## KITTITAS COUNTY COMMUNITY DEVELOPMENT SERVICES

**Subject:** CDS Review of LPF-20-00001 Big Creek Trails Final Plat – Request for additional information

CDS has reviewed the materials submitted for your final plat application LPF-20-00001 Big Creek Trails Division 1 for consistency with the conditions outlined in the associated preliminary approval documents for RZ-15-00001, [see Ordinance \(2016-24\) and Resolution \(2017-105\)](#).

BIG CREEK - DIVISION I
A PORTION OF THE N 1/2 OF THE SE 1/4 OF SECTION 29,
TOWNSHIP 20 NORTH, RANGE 14 EAST, W.M.
KITTITAS COUNTY, WASHINGTON

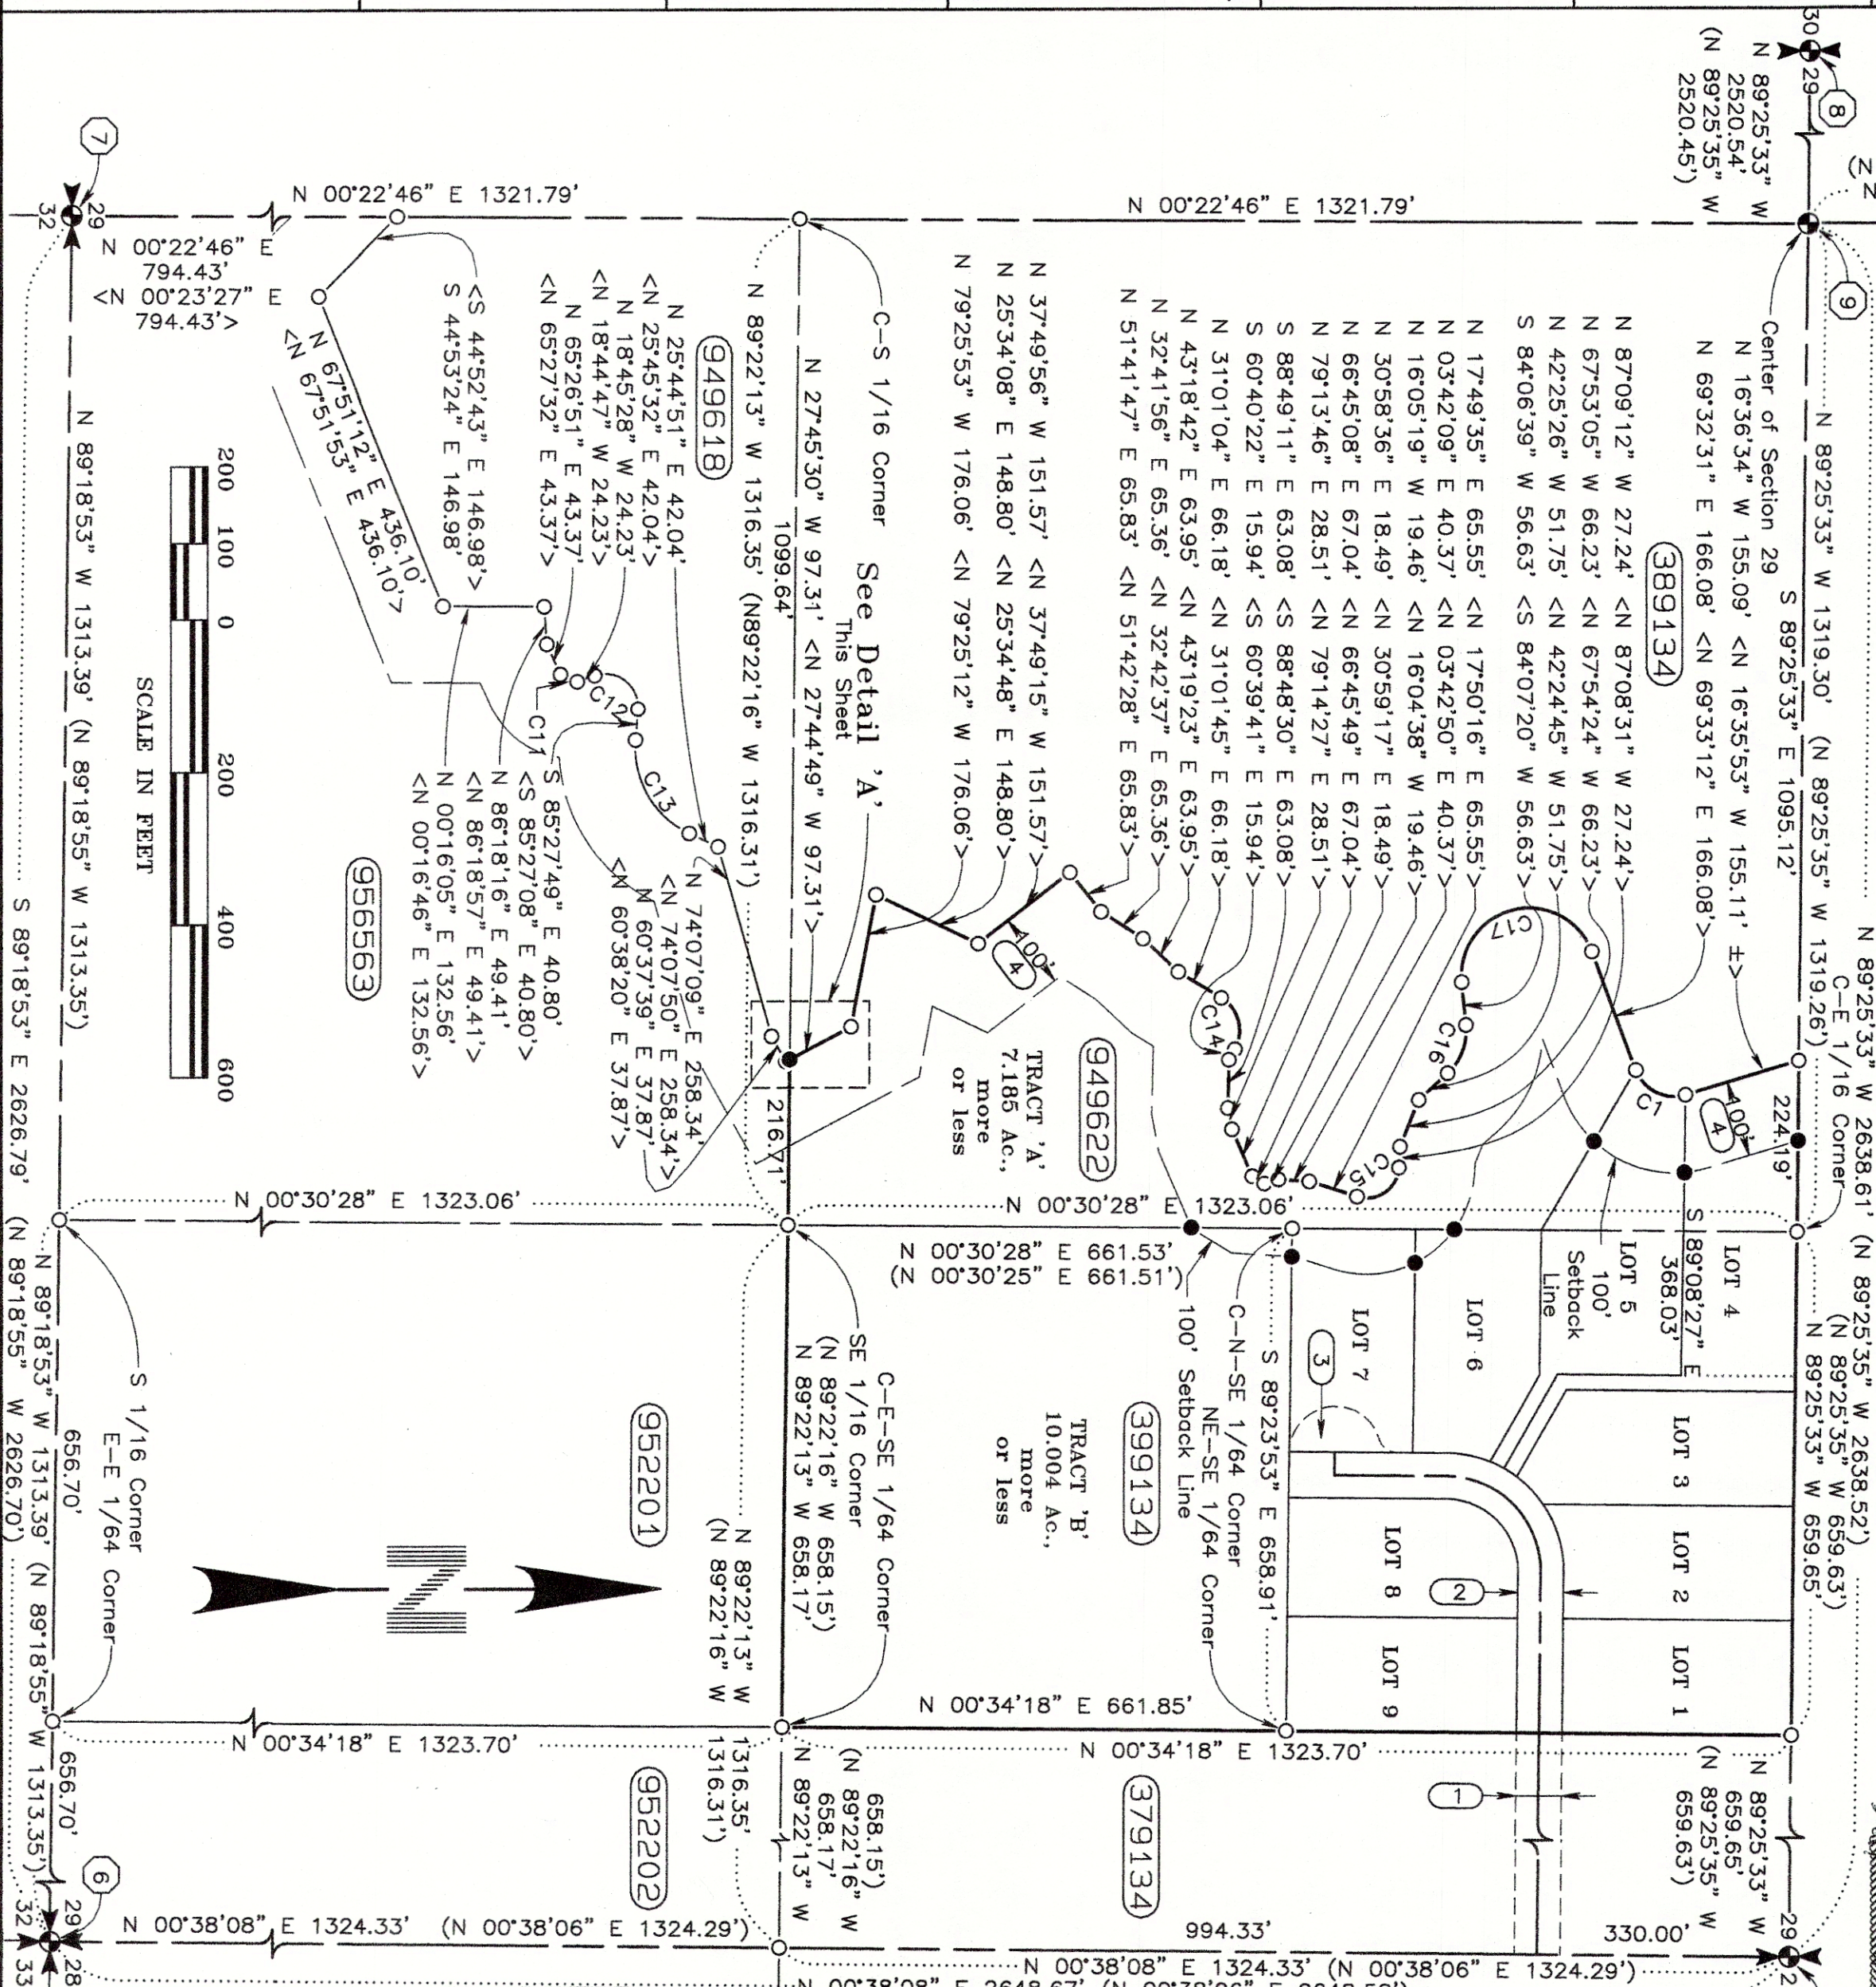
The survey submitted with your application demonstrates a 100-foot buffer/riparian corridor from the stream and appears to encroach upon proposed parcels 6 and 7. The condition requires a 200-foot buffer. The final survey will need to be updated to meet these conditions and a [site plan](#) will need to be provided demonstrating the location of the four required signs along the Big Creek Corridor that identify the area as a wildlife movement corridor.

1. The final survey will need to be updated to demonstrate the 200-foot riparian and wildlife movement corridor, all wetlands, and critical areas. A site plan demonstrating the four required signs identifying the wildlife corridor will also need to be submitted
2. Photo evidence of the installed riparian and wildlife movement corridor signs
3. Proof of WDFW easements to maintain fish diversions and fish screens on Big Creek
4. The face of the plat shall include the final plat number LPF-20-00001
5. Submittal of a copy of the original landscape plan.
